Amended planning application no 3/2022/0421

Regarding amended planning. Concerns as follows :-

PROPOSED NORTH EAST ELEVATION (FRONT). SCALE 1:100

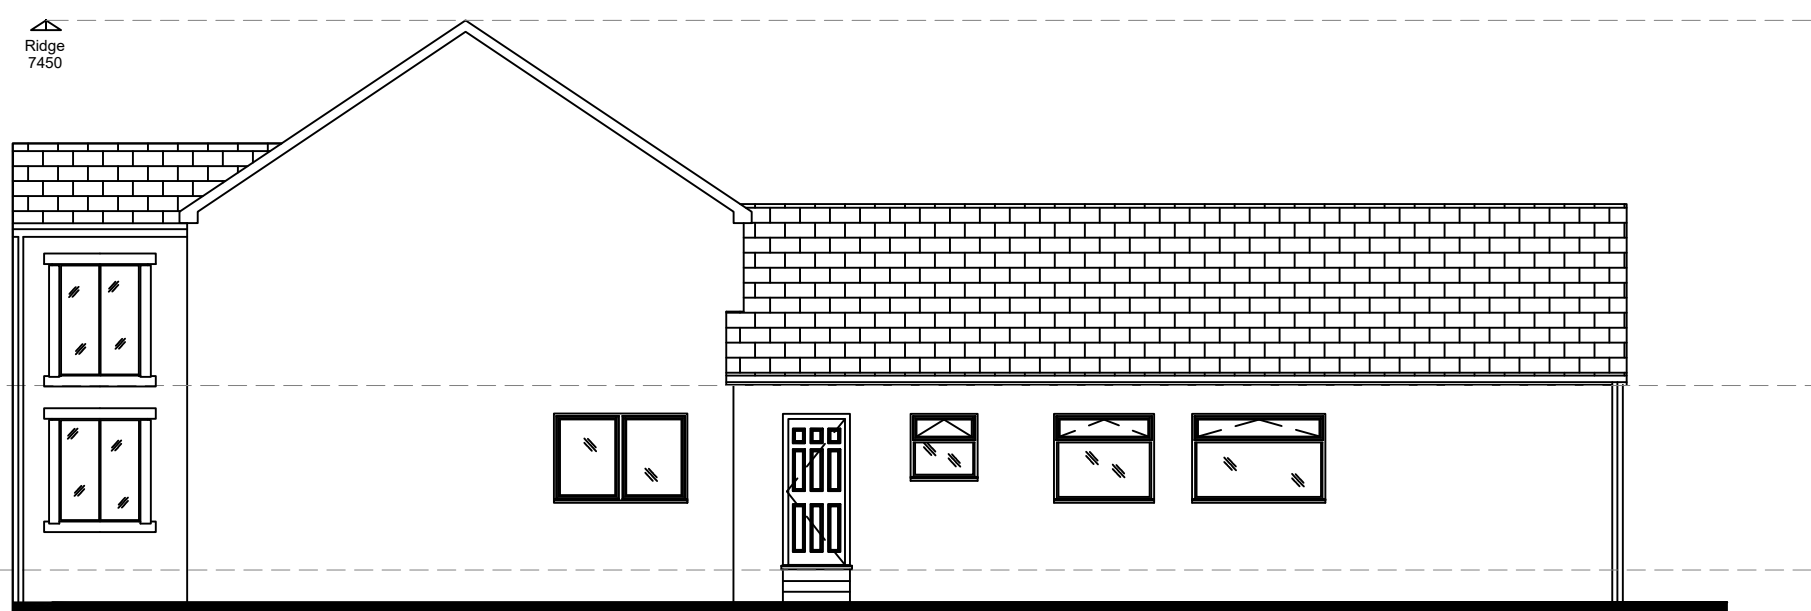
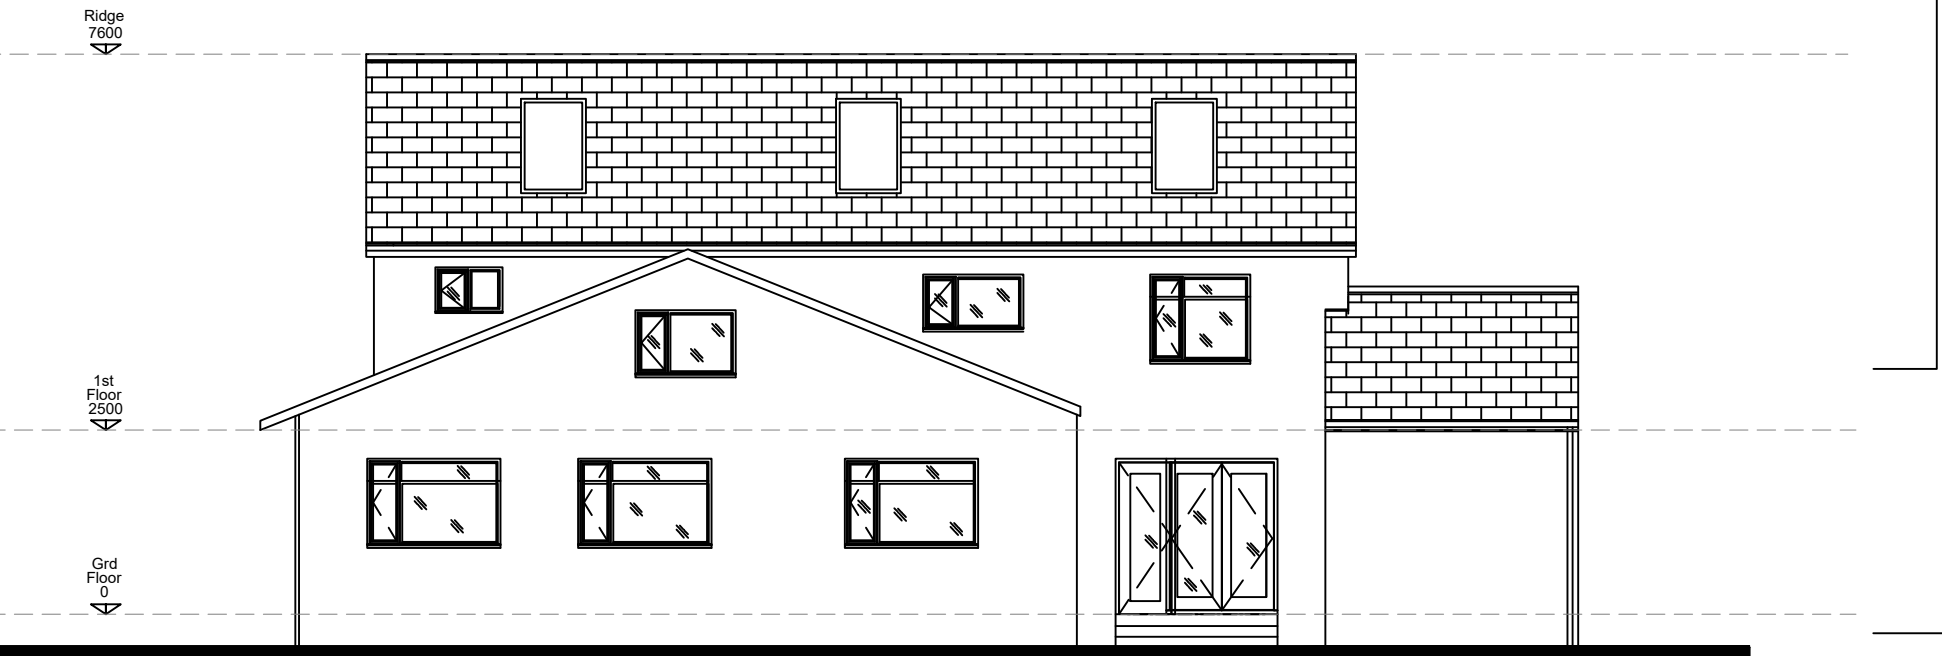
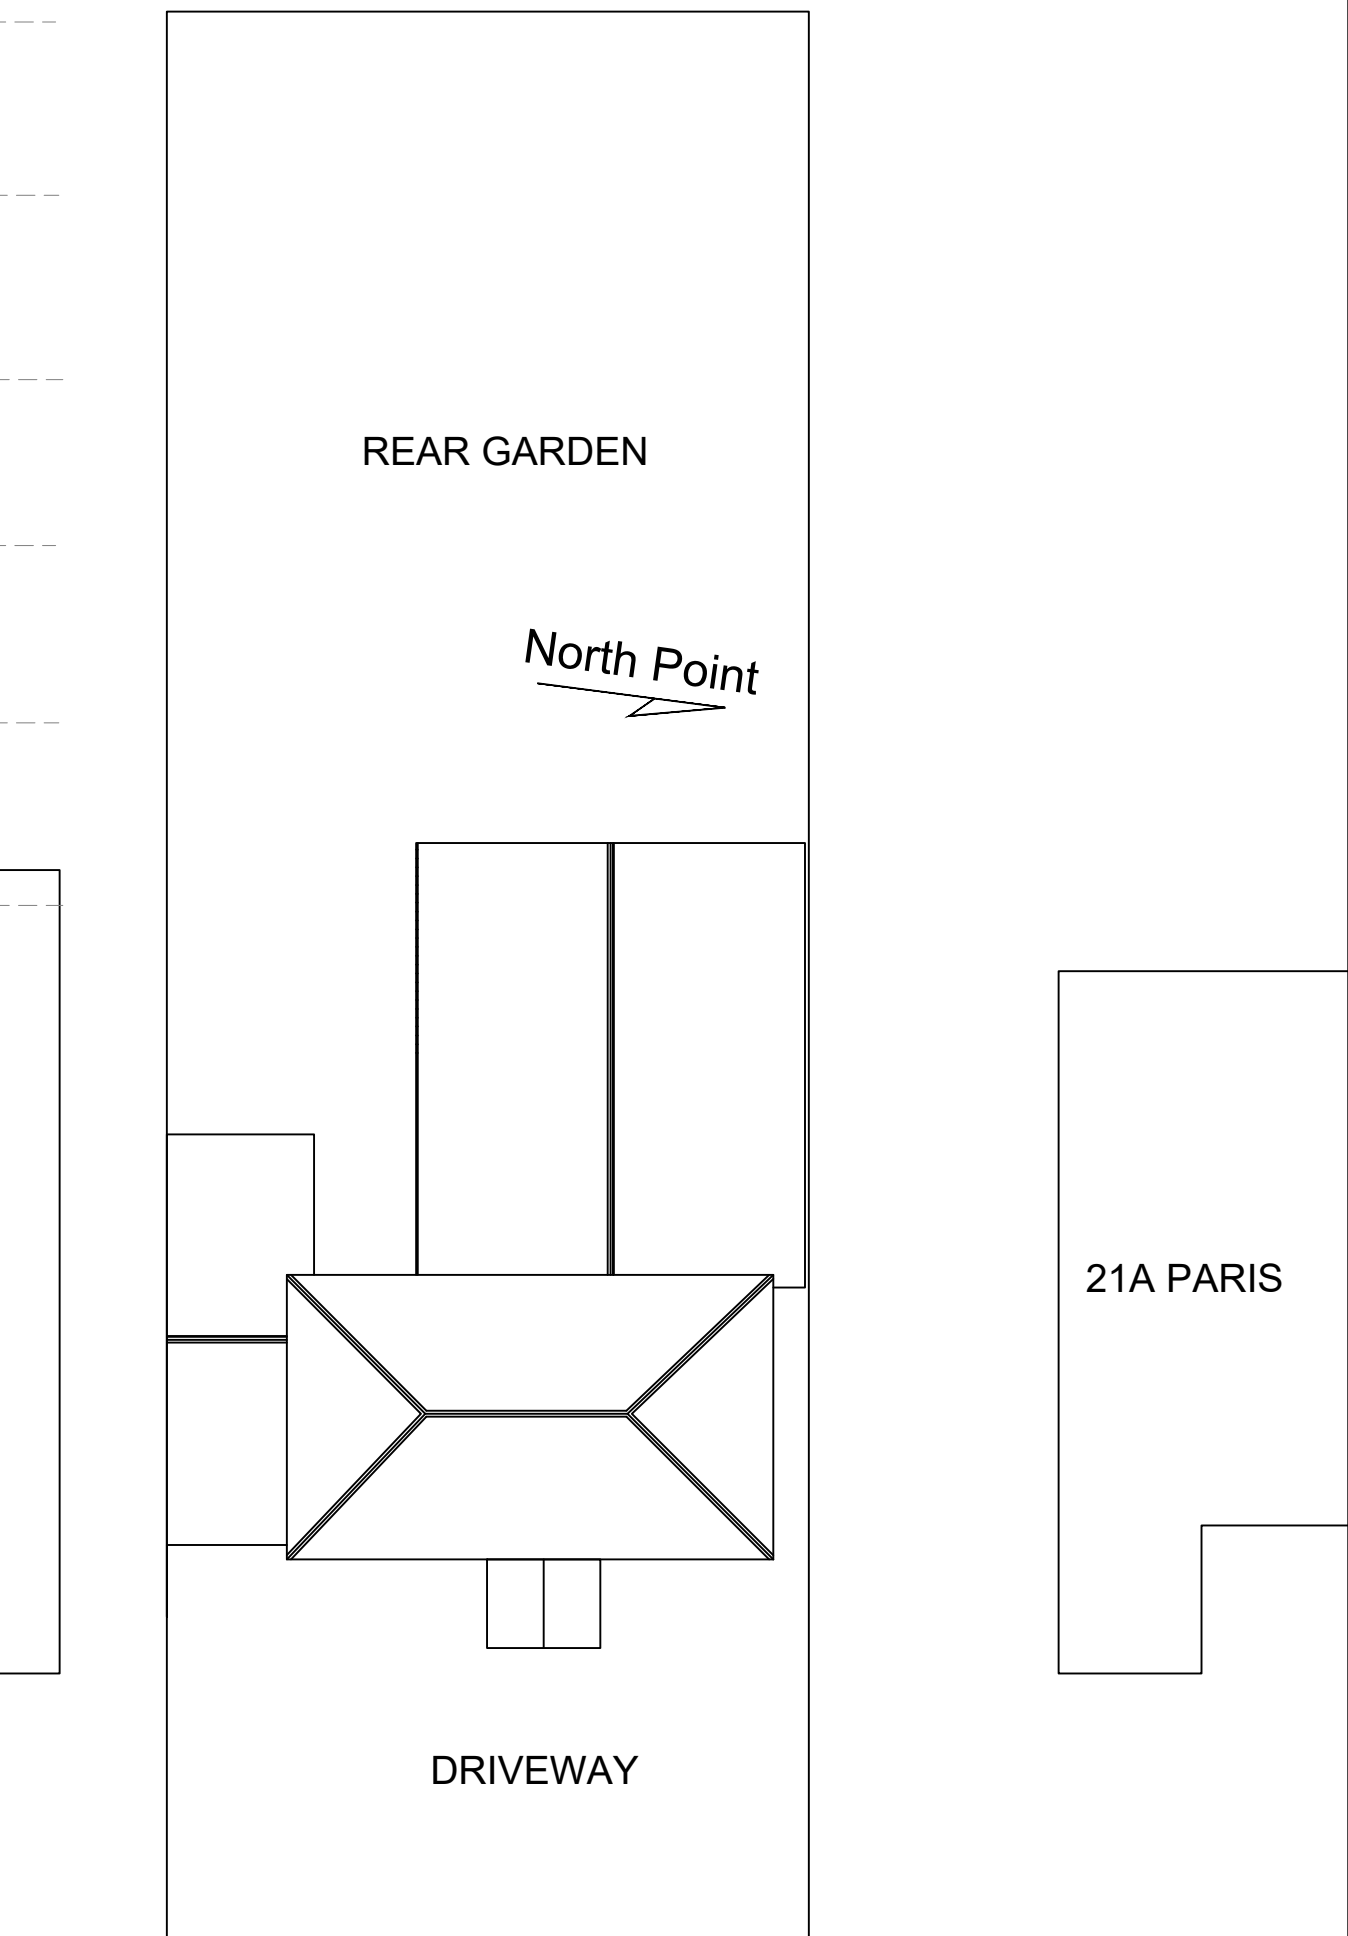
1. Loss of privacy due to new added large balconies and large window lights on the 3rd floor this would enable occupants to directly [REDACTED]
